WEST SUSSEX COUNTY COUNCIL CONSULTATION

TO:	Arun District Council FAO: Michael Eastham
FROM:	Stephen Gee WSCC - Highways Authority
DATE:	19 December 2019
LOCATION:	Land off Arundel Road Angmering BN16 4ET
SUBJECT:	A/122/19/OUT Outline application with some matters reserved for the erection of up to 160 dwellings with public open space, landscaping and sustainable drainage systems (SuDs), vehicular access point from Arundel Road together with up to 557 square metres of B1/B2 units with associated parking provision & vehicular access point from Arundel Road & land made available for expansion of current sports pitch provision to form a sports-hub (following the demolition of existing commercial units and one bungalow) (resubmission following A/36/18//OUT). This application is a Departure from the Development Plan. An amendment received.
DATE OF SITE VISIT:	
RECOMMENDATION:	No Objection
S106 CONTRIBUTION TOTAL:	£ See below for breakdown.

Z:\projects\2020 Arundel Road, Angmering\CAD\Croft Drawings\2020-F01 REV D.dwg

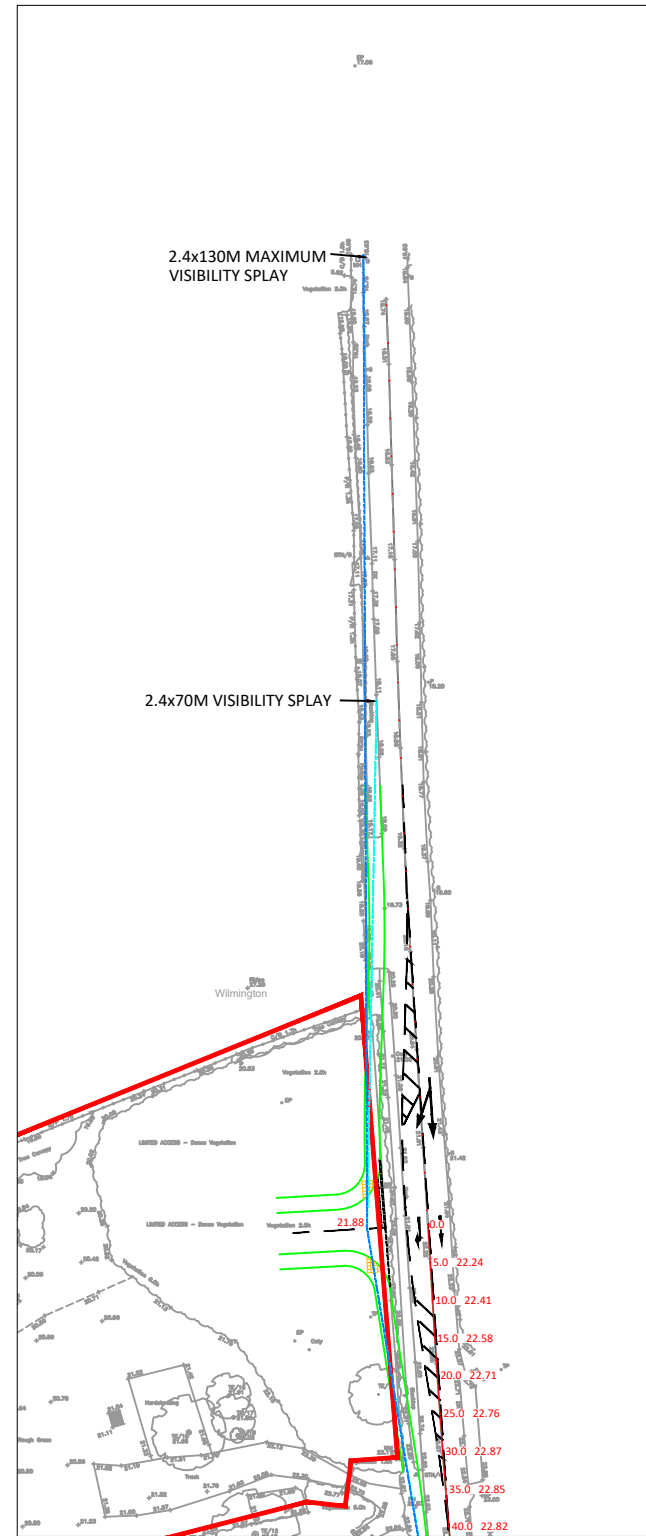
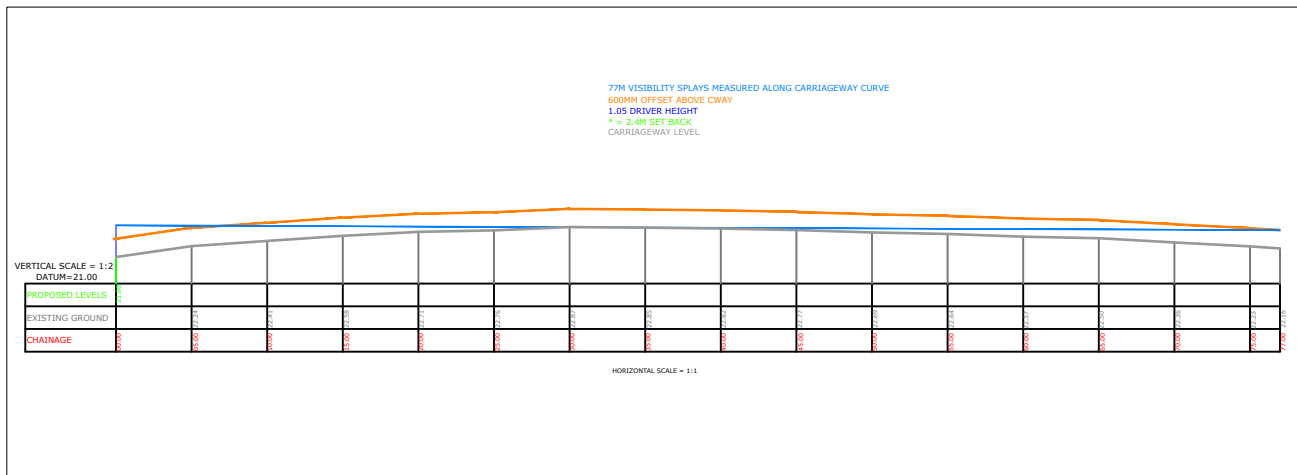
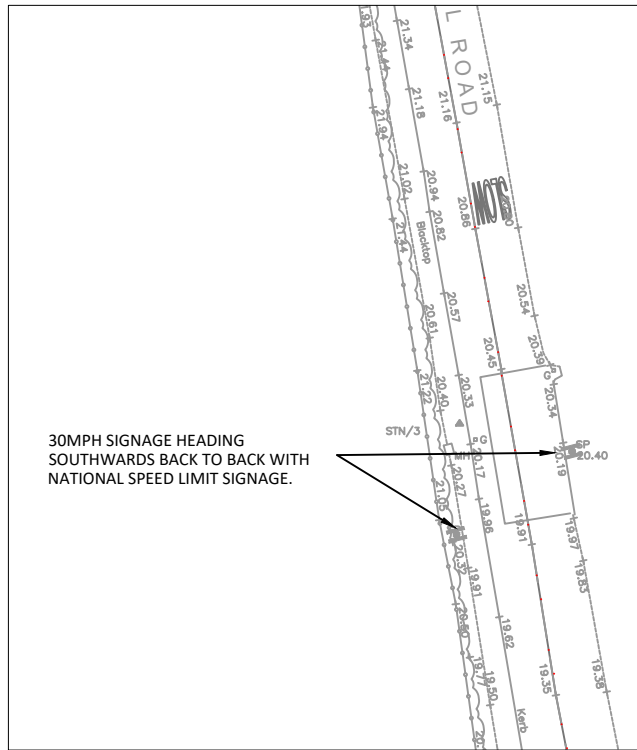
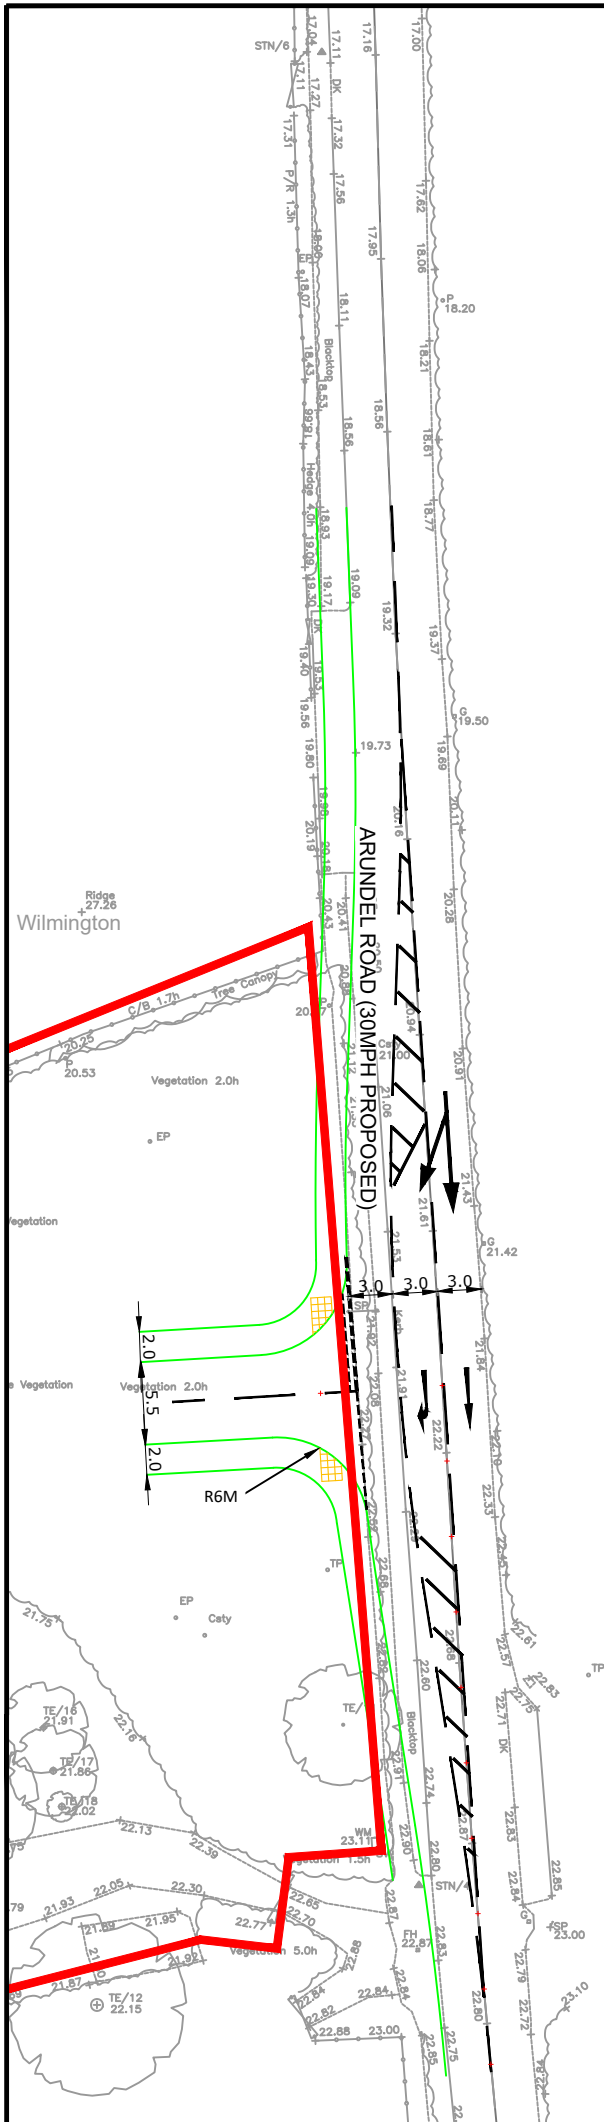
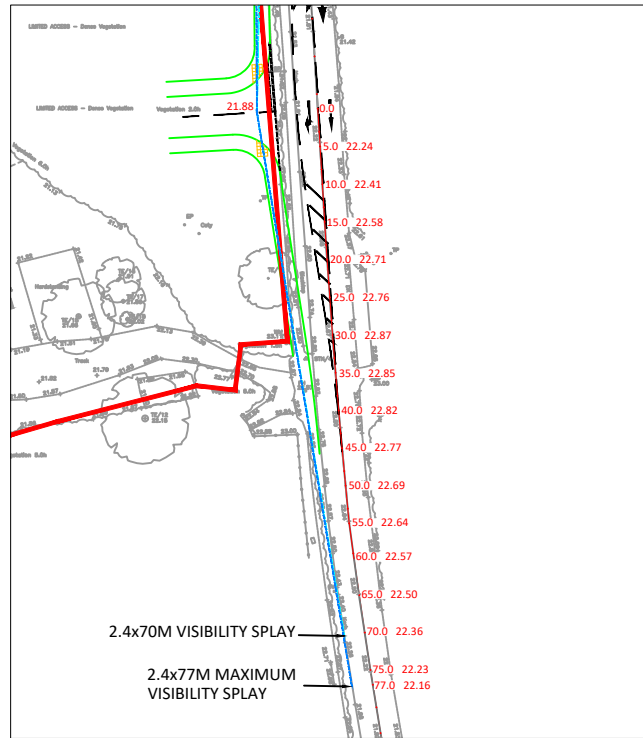
A revised drawing ref 2020-F01 Rev D has been provided which details that the maximum achievable visibility splay is 2.4mx 77m. The limiting factor is the vertical alignment. The splays are provided in excess of MfS requirements (of 2.4m x59m) and have been shown in accordance with MfS parameter of a 600m offset above the carriageway from a drivers perspective of 1.05. The use of MfS is considered appropriate given the recorded 85th% speeds of 37mph (including wet weather adjustment) and the presence of a footway on the western side of the carriageway.
